Consultee Comments for Planning Application 17962/24

Application Number: 17962/24

Address: Beechwood Shady Lane Bromley Cross Bolton BL7 9AF

Proposal: CHANGE OF USE FROM A MIXED USE (CHILDREN'S NURSERY WITH FLAT ABOVE) TO 1NO. DWELLING HOUSE.

Drawing Number	Description	Rev
24(05)100	Proposed Floor Plans	-

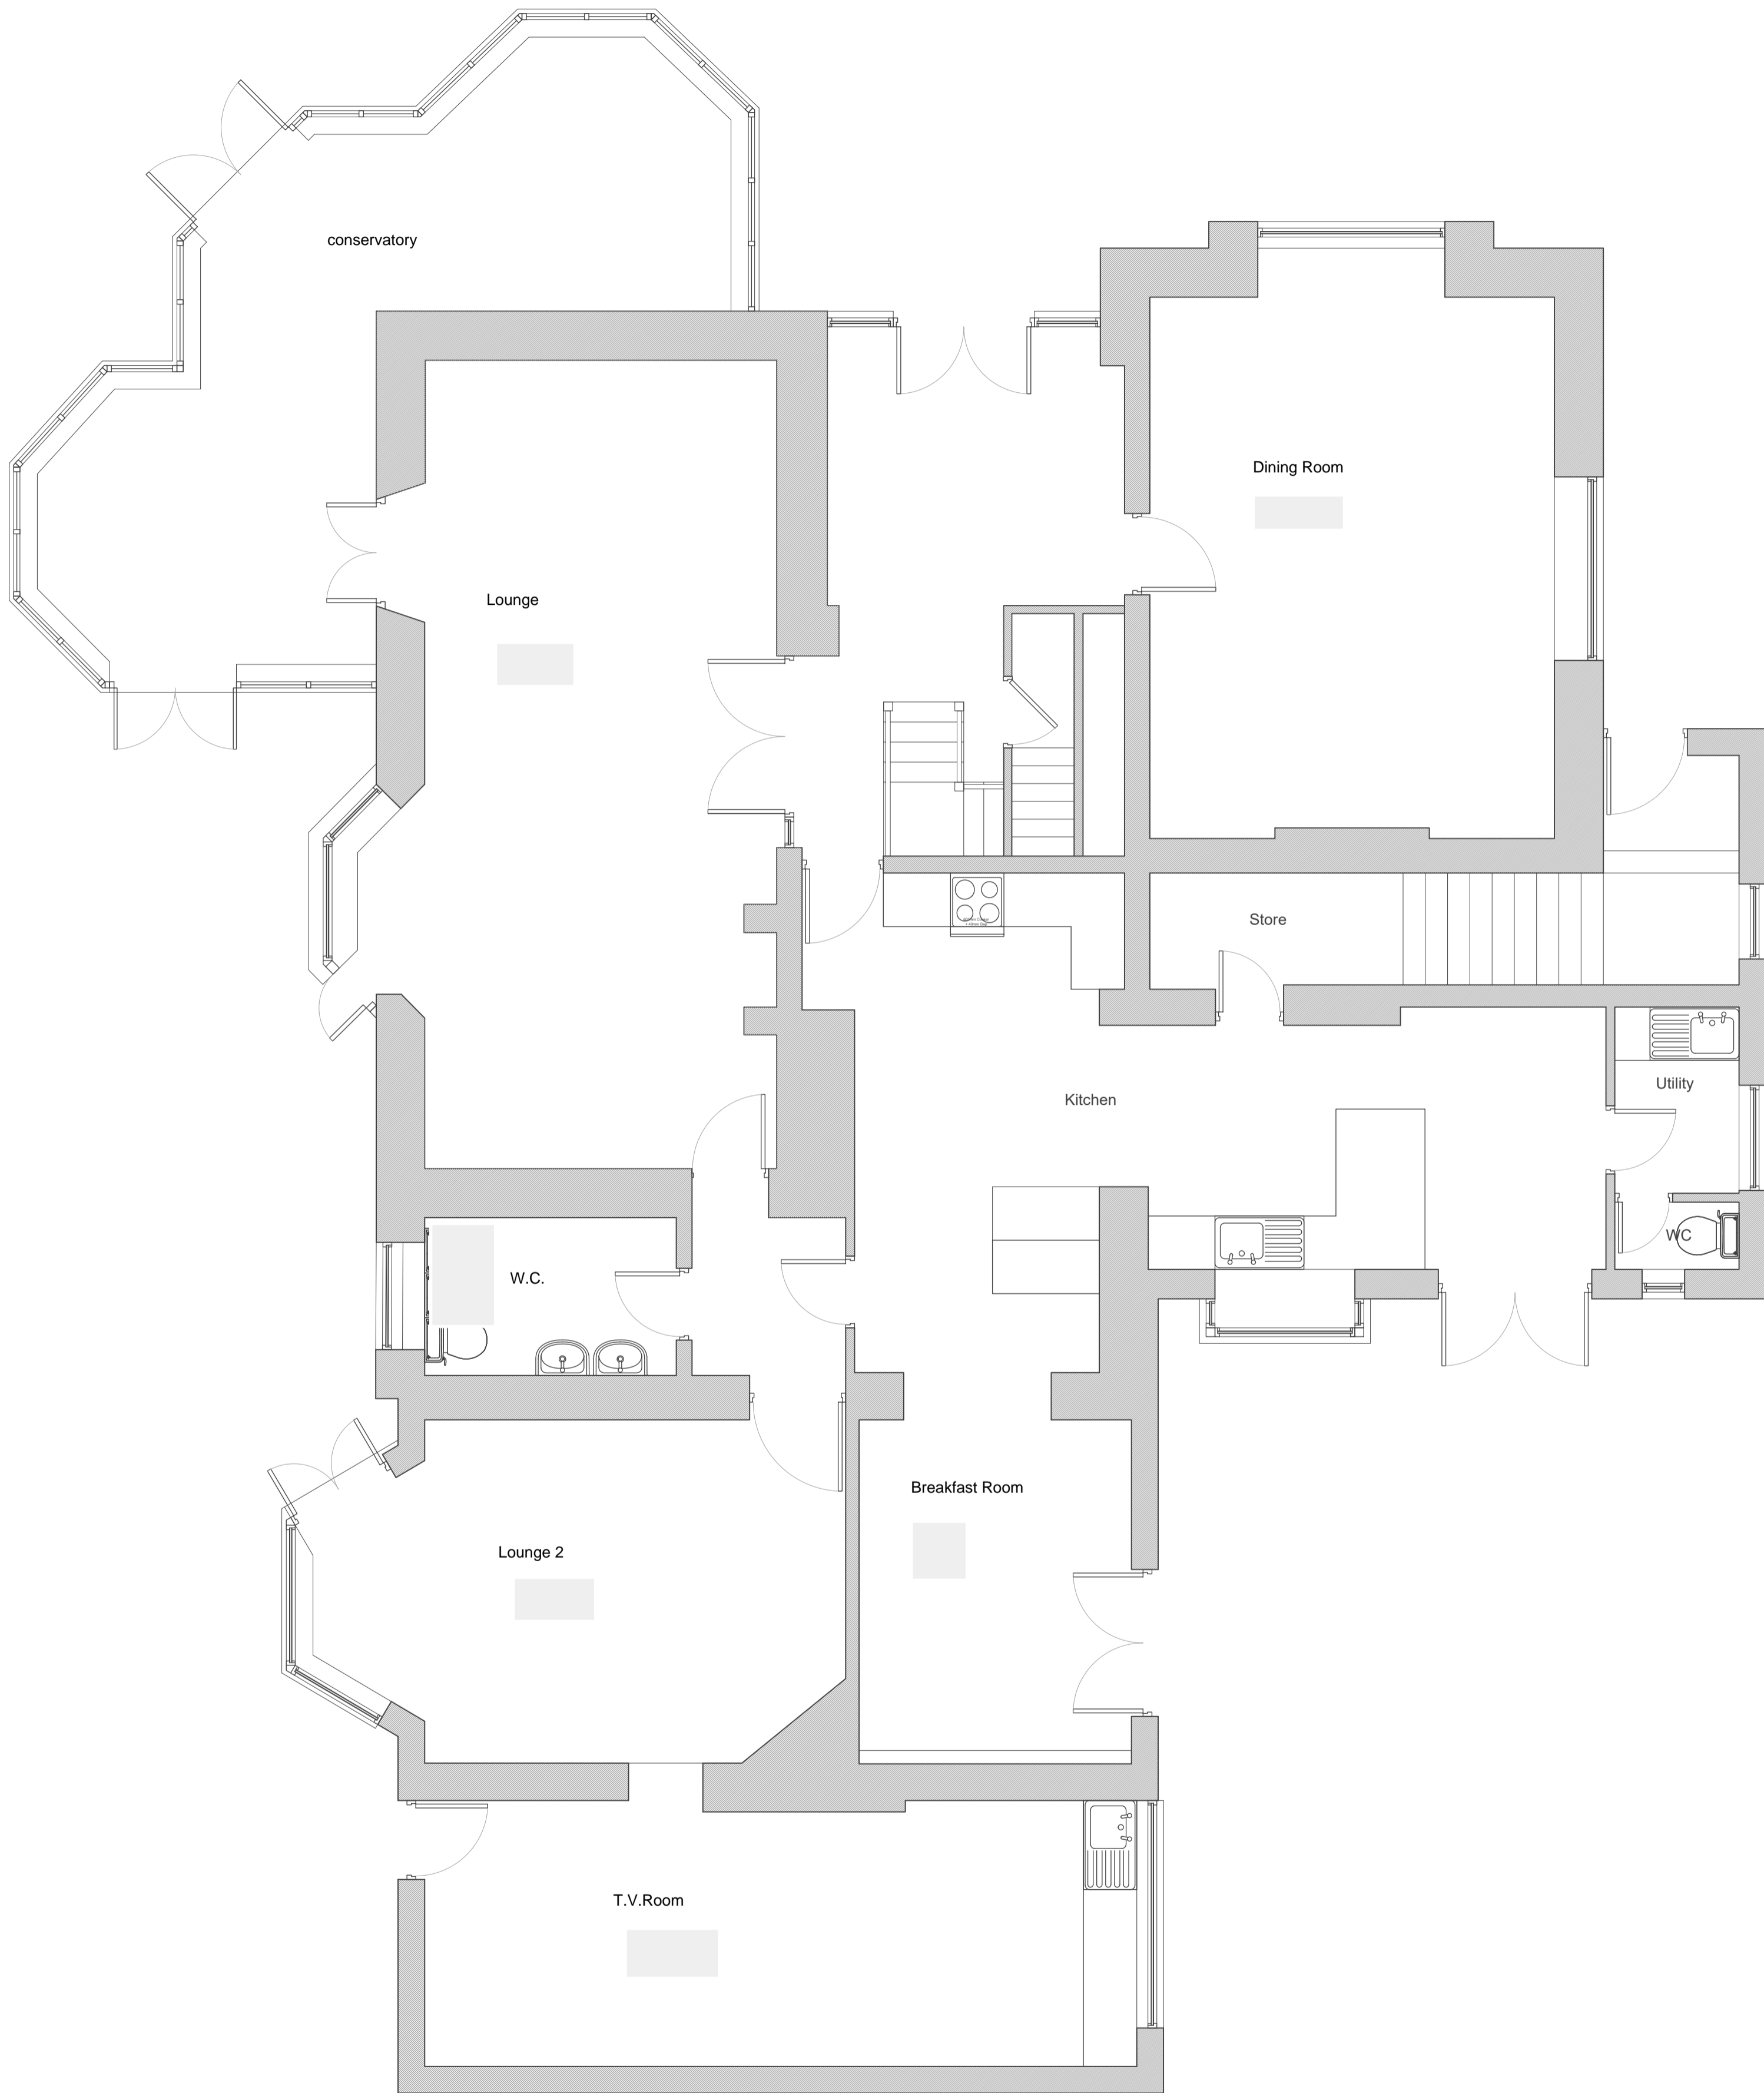
If the flat at first floor level is to be retained then the following condition should be attached :-

No development shall take place unless and until a scheme to acoustically insulate the

floor(s)/ceiling(s) between the flat at first floor level and the residential dwelling at ground floor level in line with guidance in Section 5 of Building Regulations 2014, Approved Document E, has been submitted to and approved by the Local Planning Authority. Such works that form the approved scheme shall be completed before the commencement of the use and retained thereafter.
